Design Note

Project Begbroke Innovation District
 Subject EA Responses to Flood Risk Comments
 Project no 052188
 Date 21 February 2024

Revision	Description	Issued by	Date	Approved (signature)
00	Initial Draft EA Response to Objection on the basis of Flood Risk	GJ	21/02/2024

Figure 5.1: Maximum modelled depth in the 3.33% AEP event, 11 hour storm duration

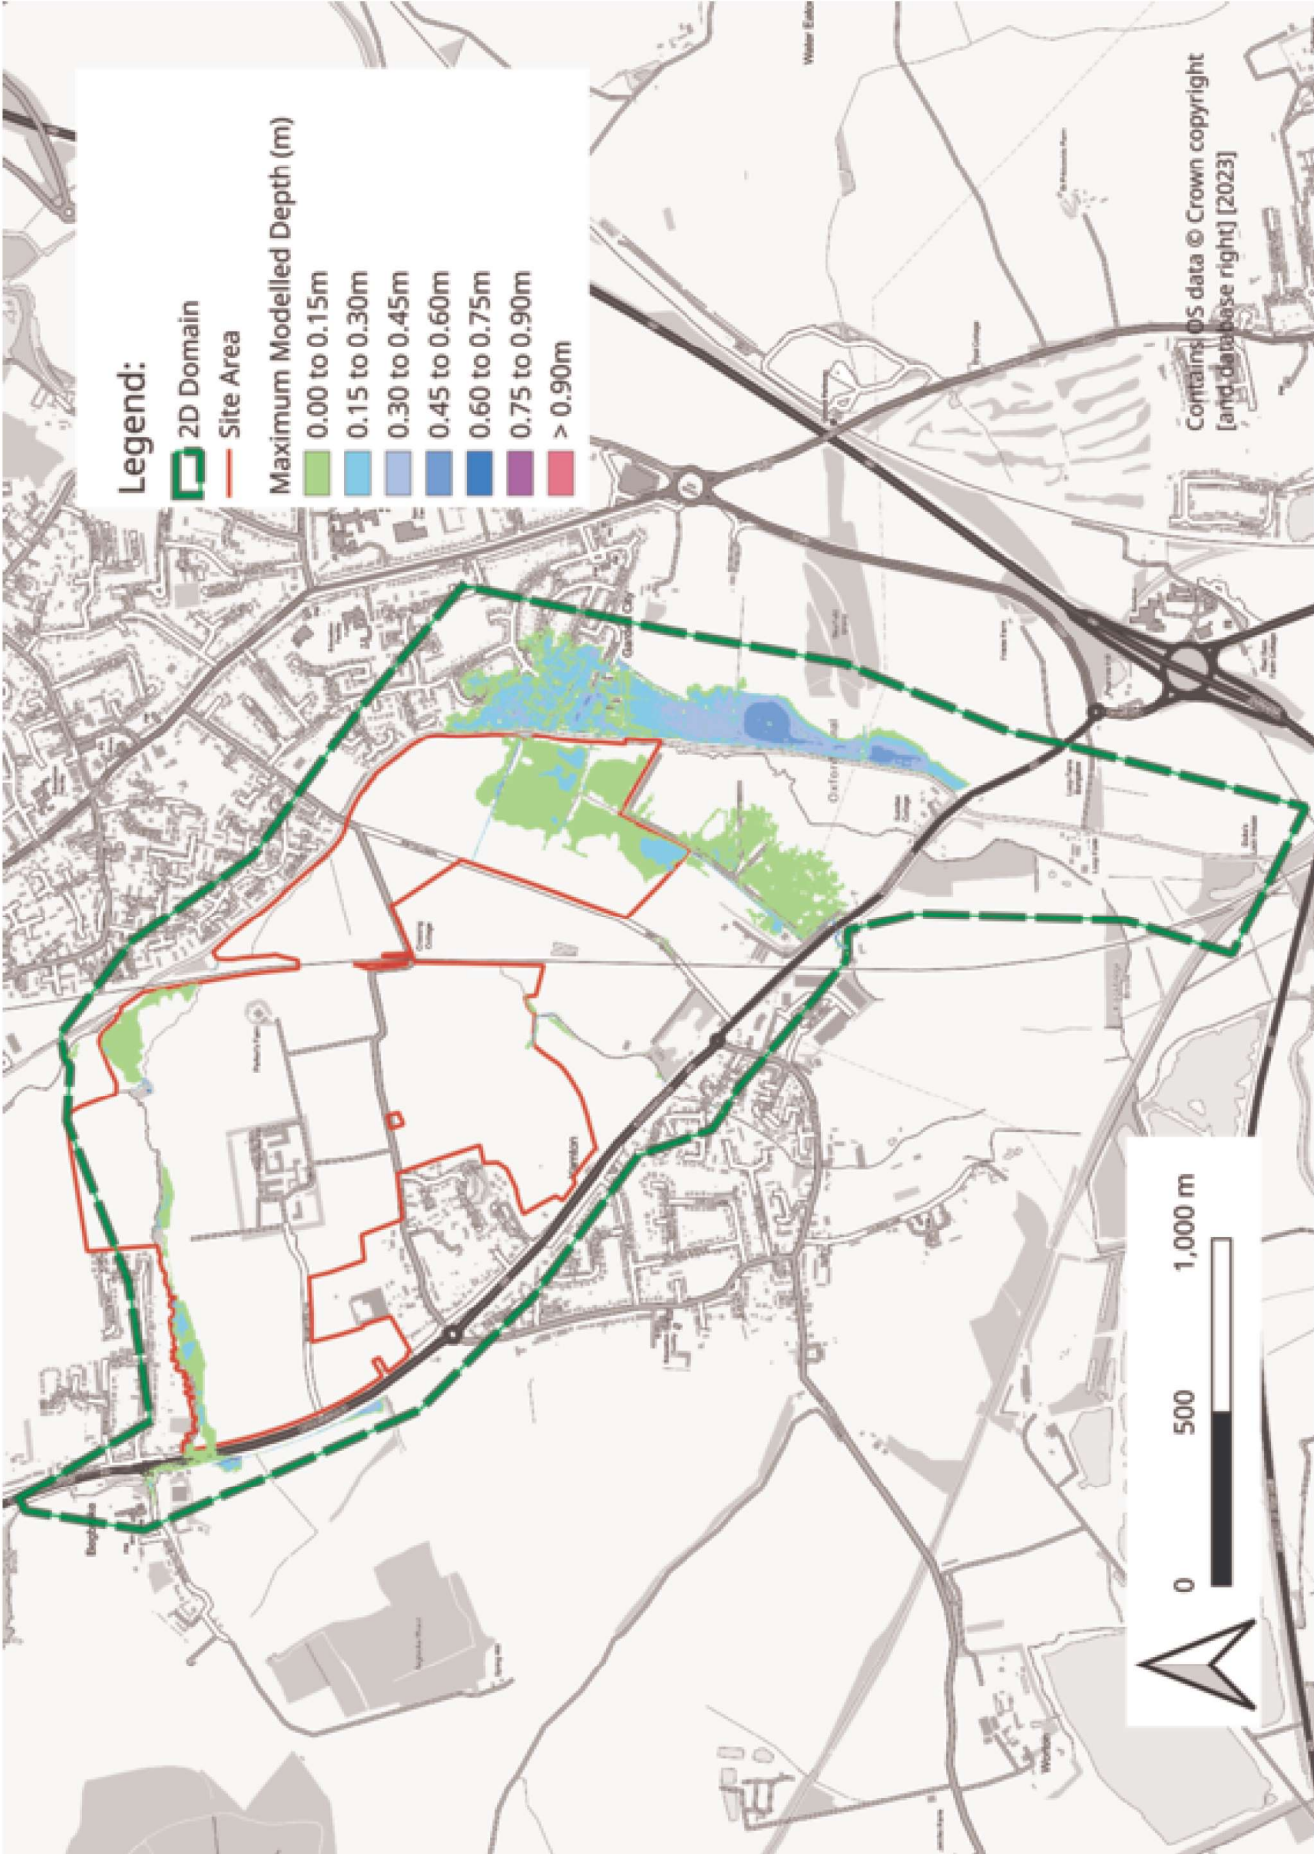
4	Flood Zone 3B	
4.1	Flood Zone 3b (functional floodplain) is where water has to flow or be stored in times of flood and should be safeguarded from development. In accordance with Figure 9 of the FRA, part of the application site is shown to lie within the 3.3% AEP flood outline as so is identified as within Flood Zone 3b (the	<p>As noted within Figure 17 of the FRA, there is no proposed development in the area shown as having a 1 in 30 year probability of flooding, as shown in Figure 9.</p> <p>The FRA demonstrates that all increases in flood extents and flood depths as a result of the re-grading of the school can be accommodated within the red line boundary</p>

<p>functional floodplain). This area is in the south of the site near the proposed secondary school. More information is required on what is proposed within this flood extent as it appears in close proximity to land level changes and 'more vulnerable' development, which would be inappropriate in Flood Zone 3b.</p> <p>In addition, land reprofiling including near the proposed school would alter Flood Zone 3b as it includes infilling a main river and creating a new stretch of river. The proposed swale in the north of the site may also create new areas of Flood Zone 3b. Therefore mapping of the proposed Flood Zone 3b is required, and it should be demonstrated that any development in these areas is appropriate in accordance with Table 2 of the Flood Zone and flood risk tables of the PPG.</p>	<p>through a flood storage area. It is recognised that the proposed updated to the storage area will need to be tested through hydraulic modelling to maintain the goal of achieving no increase in flood risk off site (page 39 of FRA) and maintaining floodplain.</p> <p>The proposed infilling of the watercourse within the Secondary School Site is work proposed on an Ordinary Watercourse, rather than a Main River. No works are proposed to the Main River. It was noted in the FRA that the works would likely require approval from the LLFA for the infilling of the ditch on the Secondary School site, which is classified as an Ordinary Watercourse. Initial consultation with the LLFA has suggested that these works would be appropriate.</p>
